MEMORANDUM

TO: Jean Fraser, Planner
FROM: David Senus, P.E. & Ashley Auger, E.I.T.
DATE: August 5, 2014
RE: 2282 Congress St. Multi-Use Development, Amended Site Plan Application

Documents Reviewed by W&C

DRAWN: CMW	DATE: OCTOBER 2013
DESIGNED: SRB	SCALE: N.T.S.
CHECKED: SRB	JOB NO. 3118
FILE NAME: 3118-DET	
SHEET	C-8.8

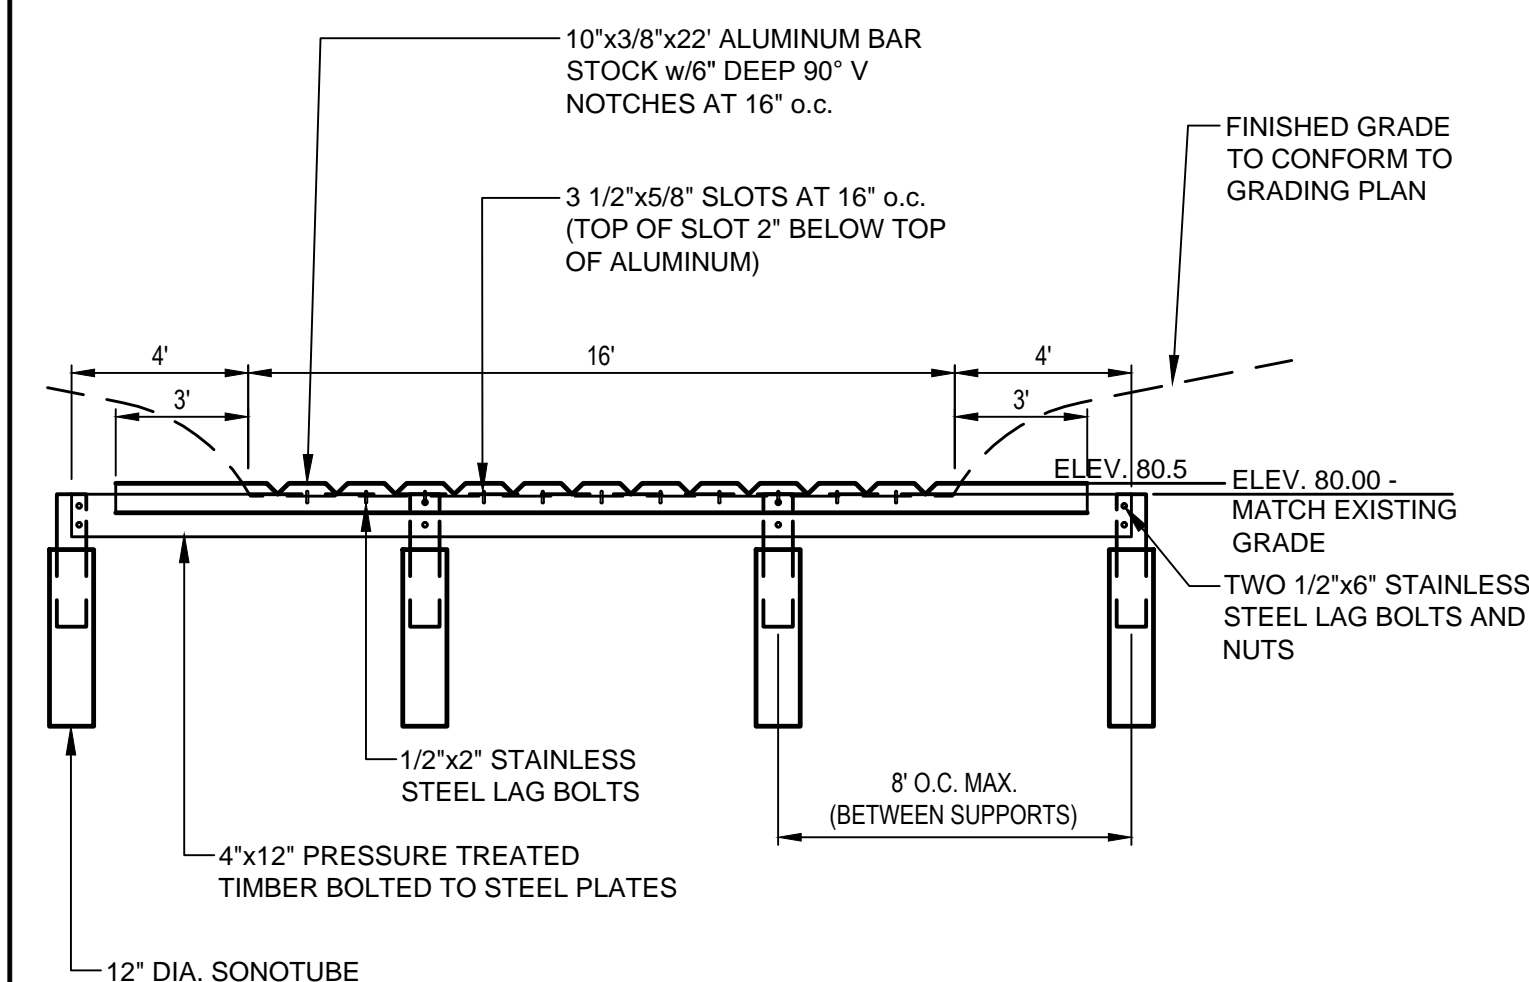
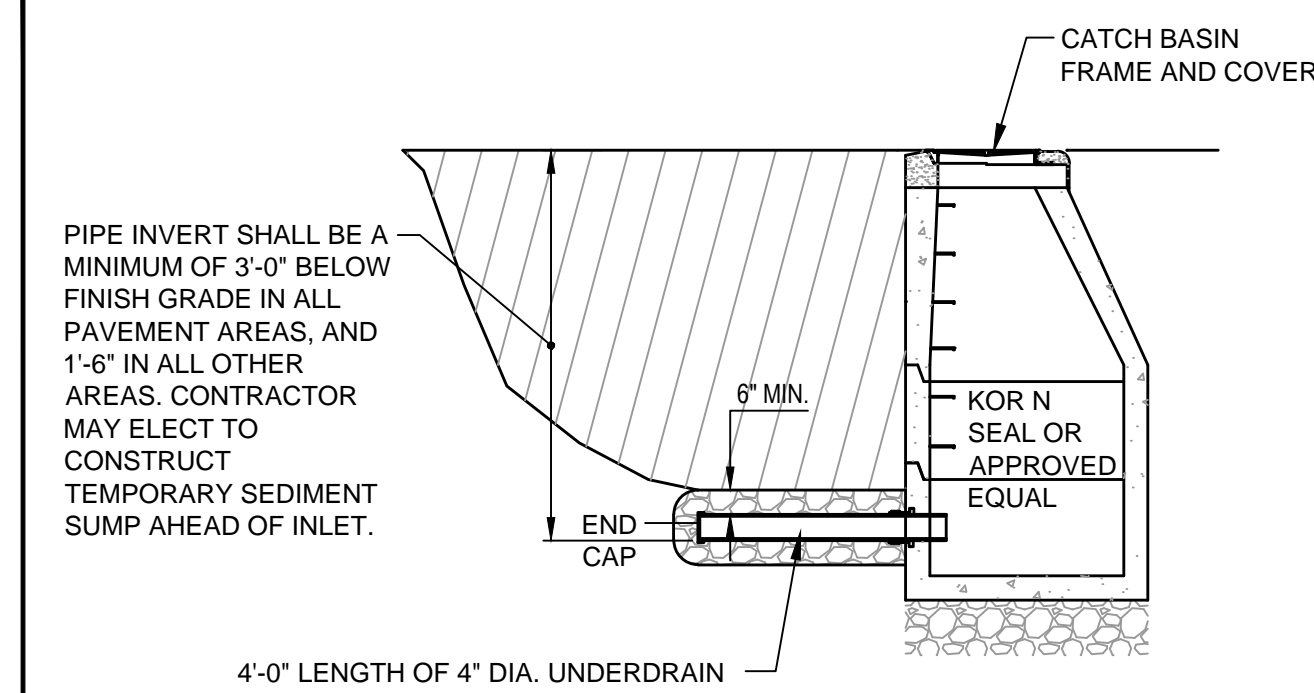
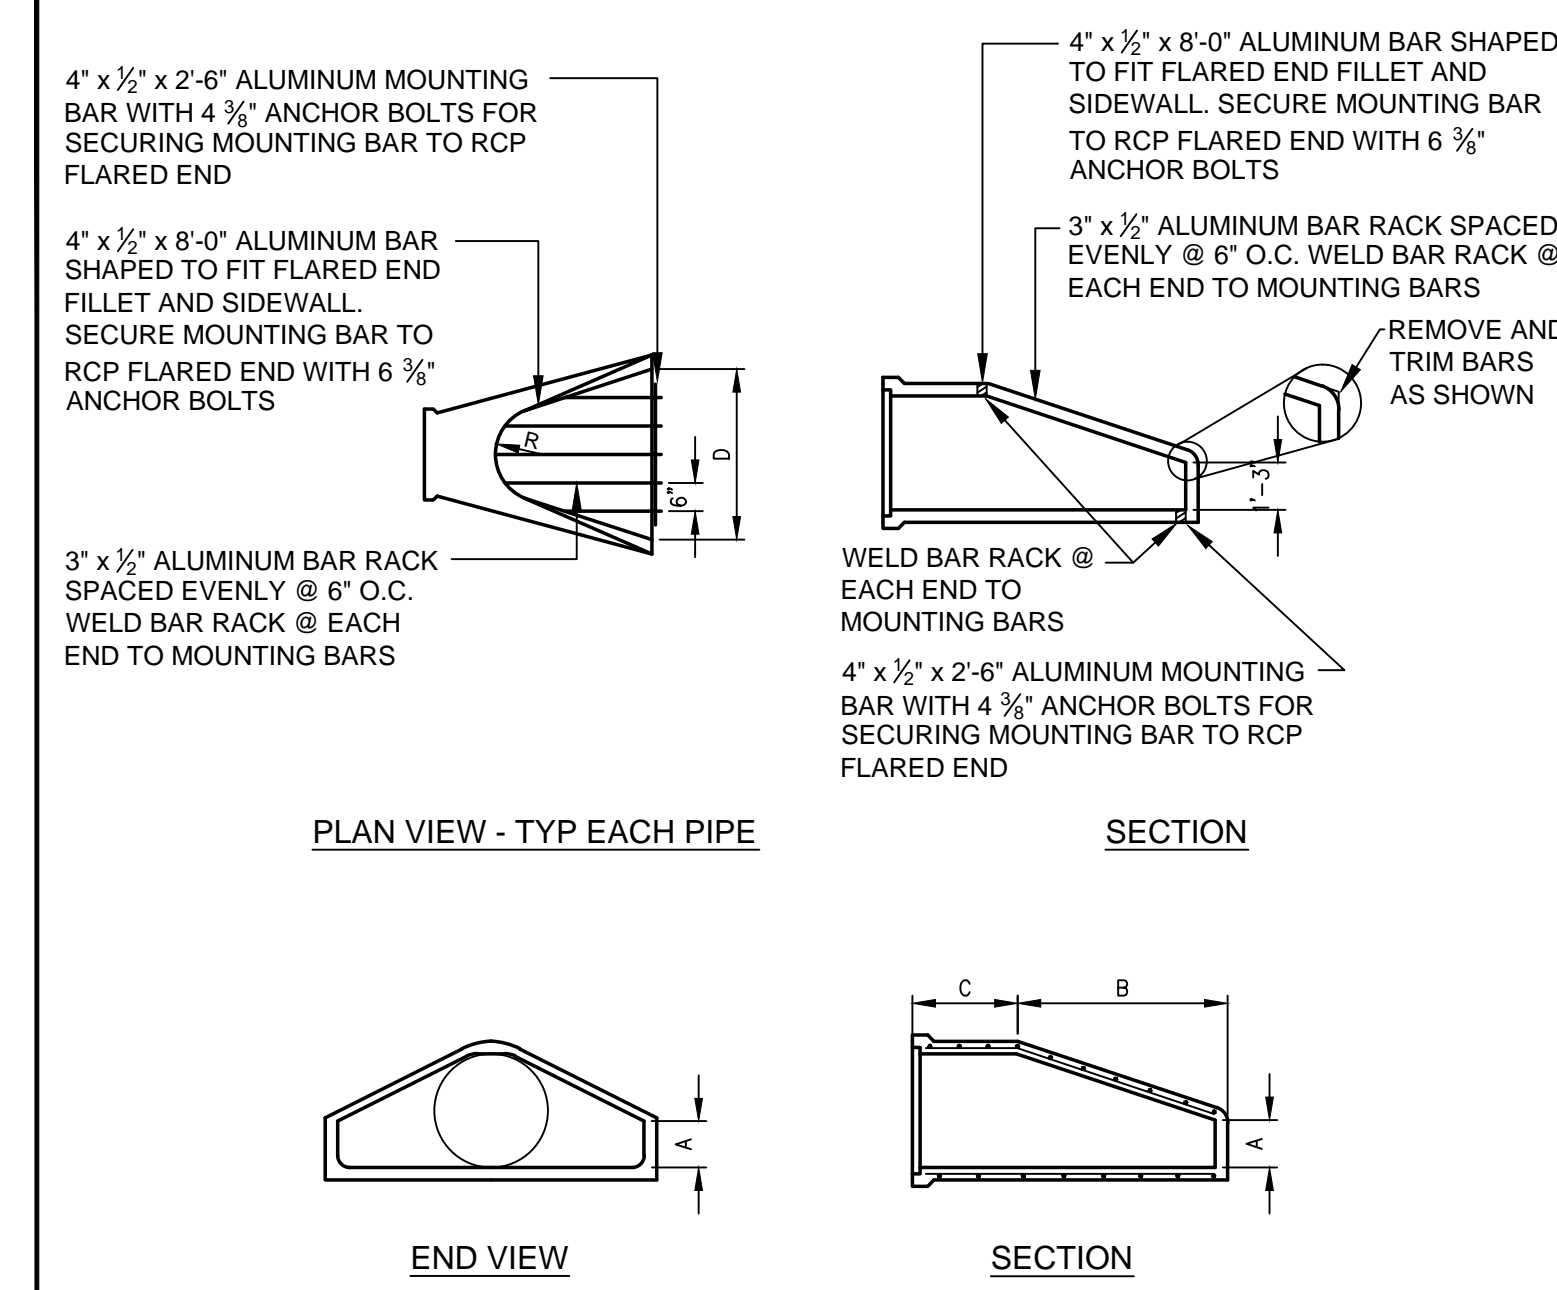
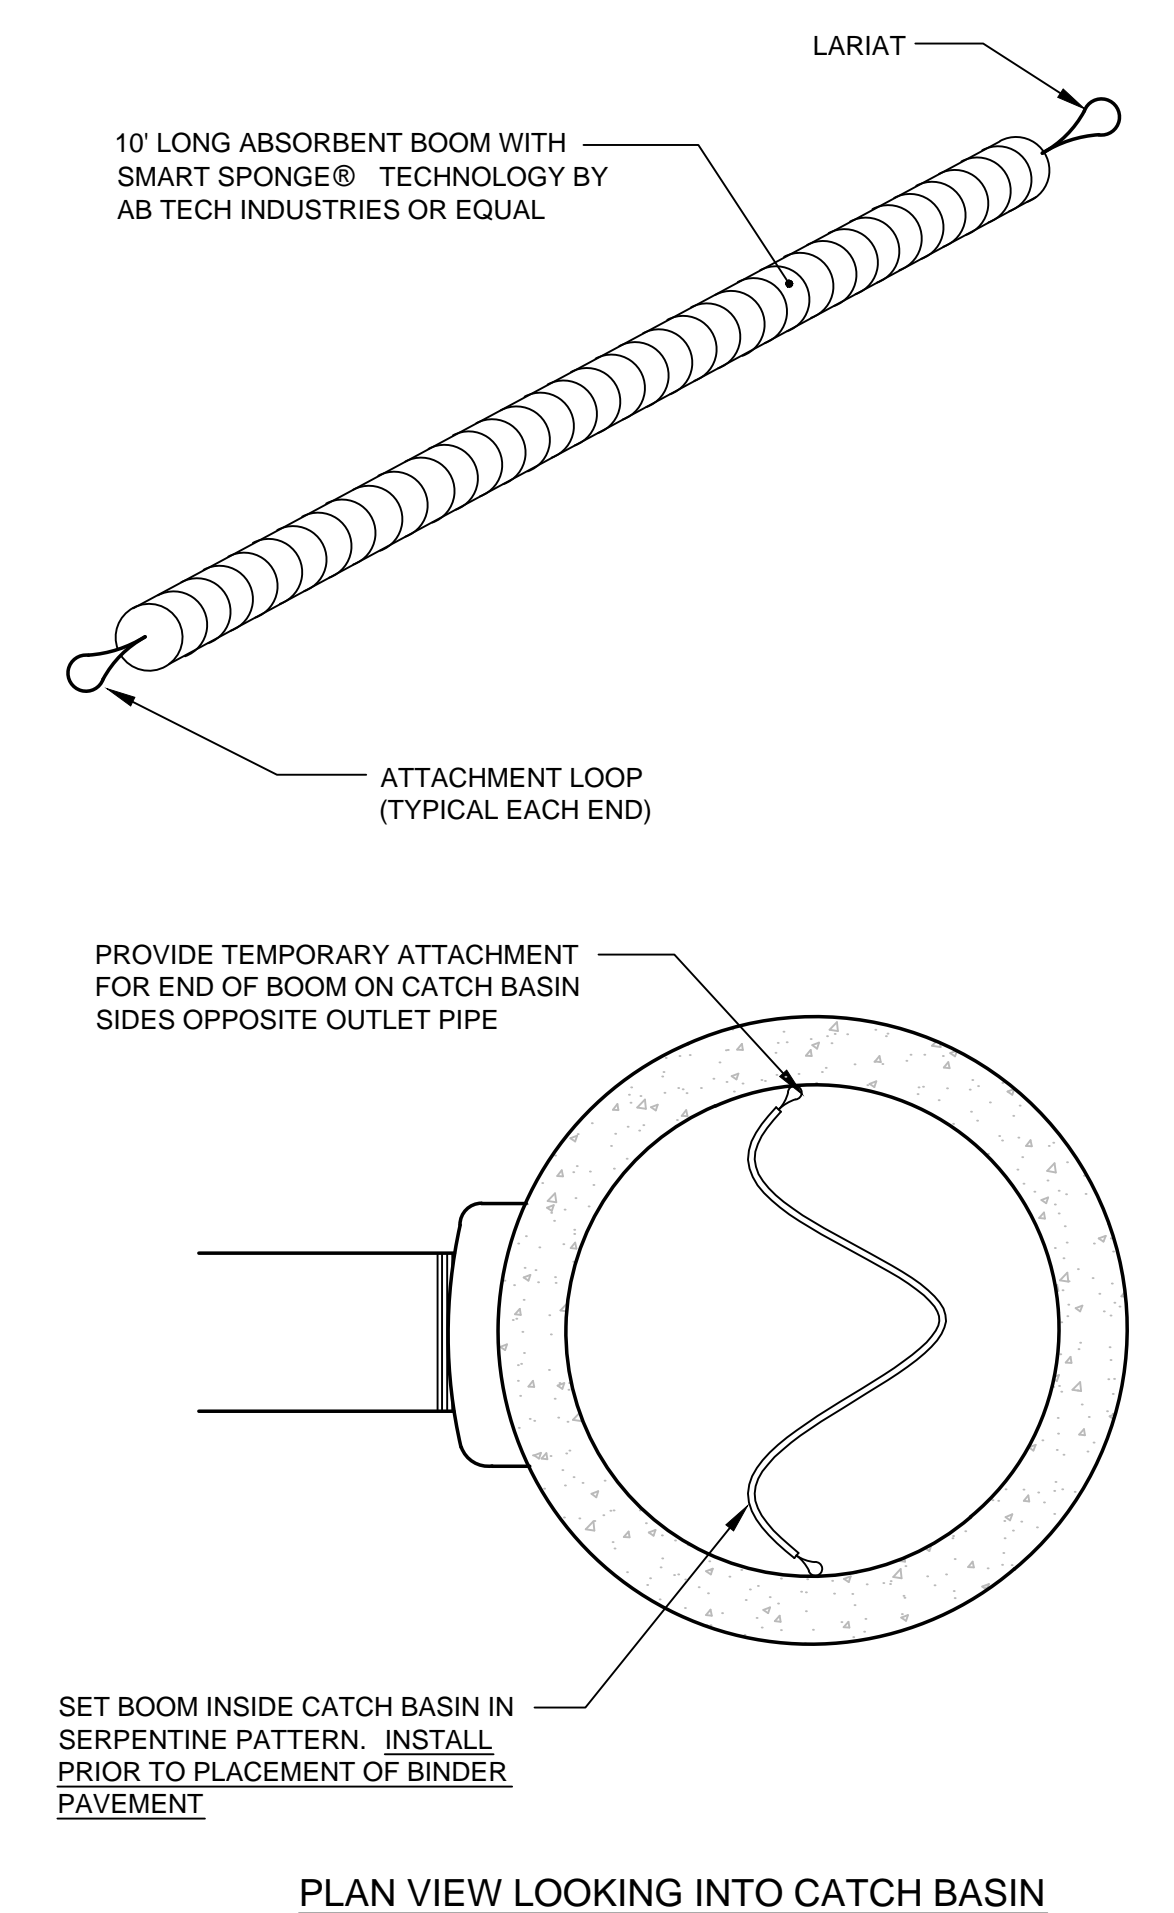
- 4) The Applicant should provide a detail for the reinforced turf spillway channel.
